KITTITAS COUNTY

MEMORANDUM

TO: Dusty Pilkington, Community Development Services
FROM: Kelly Bacon, Engineer Technician I *KB*
DATE: April 20, 2018
SUBJECT: Galloway BL-17-00024

PRELIMINARY BOUNDARY LINE ADJUSTMENT EXHIBIT		
PREPARED FOR UNIONVILLE RANCH, LLC A PORTION OF SECTIONS 5 AND 6, TOWNSHIP 19 NORTH, RANGE 17 EAST, W.M.		
KITTITAS COUNTY	WASHINGTON	
DWN BY DLP/GW	DATE 11/2017	JOB NO. 141361
CHKD BY GW	SCALE 1" = 200"	SHEET 1 OF 1

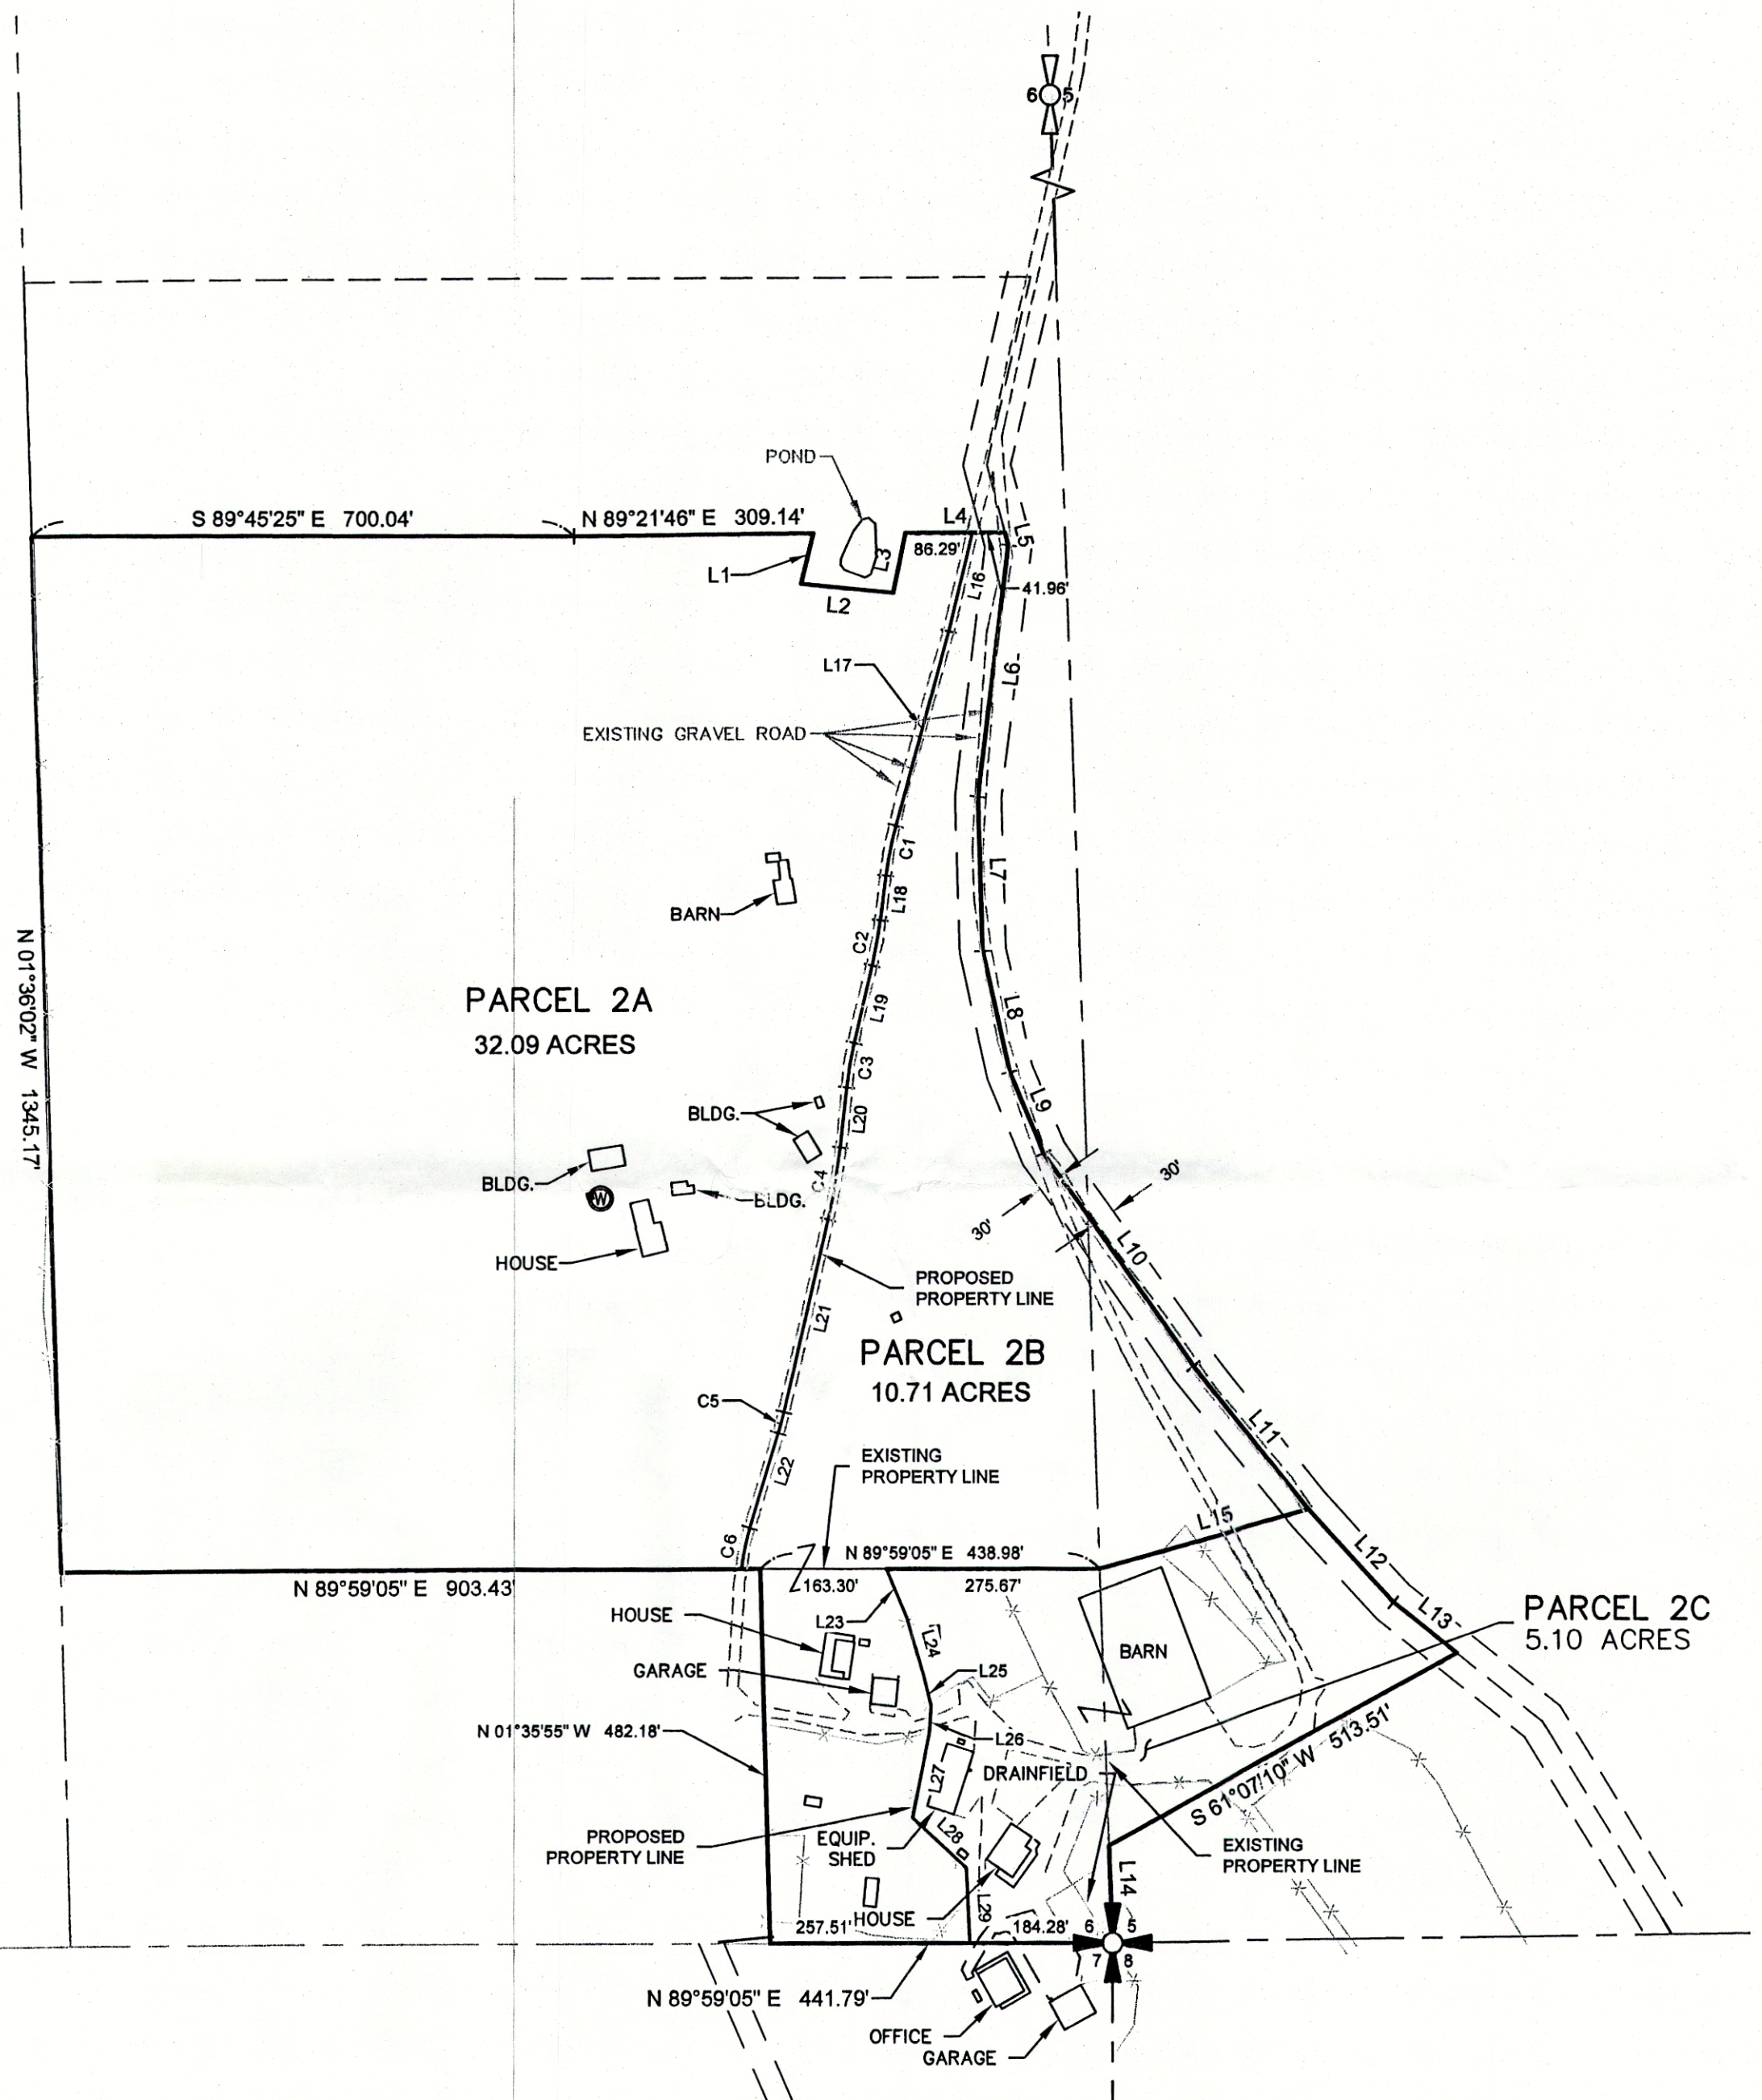
- a. Existing gravel road at the east boundary of 2A shall be a 60 foot dedicated easement and meet current Kittitas County Road Standards dated 12/15/15 for a Private Road with Average Lot Size > 10.0 Acres.

- b. A private road certification is required prior to final approval.
- c. Show access easements to all tax parcels.
- d. An approved access permit shall be required from the Kittitas County Department of Public Works prior to creating any new driveway access or performing any work within the county road right of way.

1. There is an existing wellhead near the proposed property line between parcels 2B and 2C that is not shown in the Encompass drawing. According to the records I have, the well head not shown looks like it is right next to the proposed property line which is following a fence line. I will need this existing wellhead included in a drawing. The proposed property line has to be at least 50 feet from the existing well.
2. I also need to see the location of the existing drainfield for the house on the proposed parcel 2B. It is also not shown.
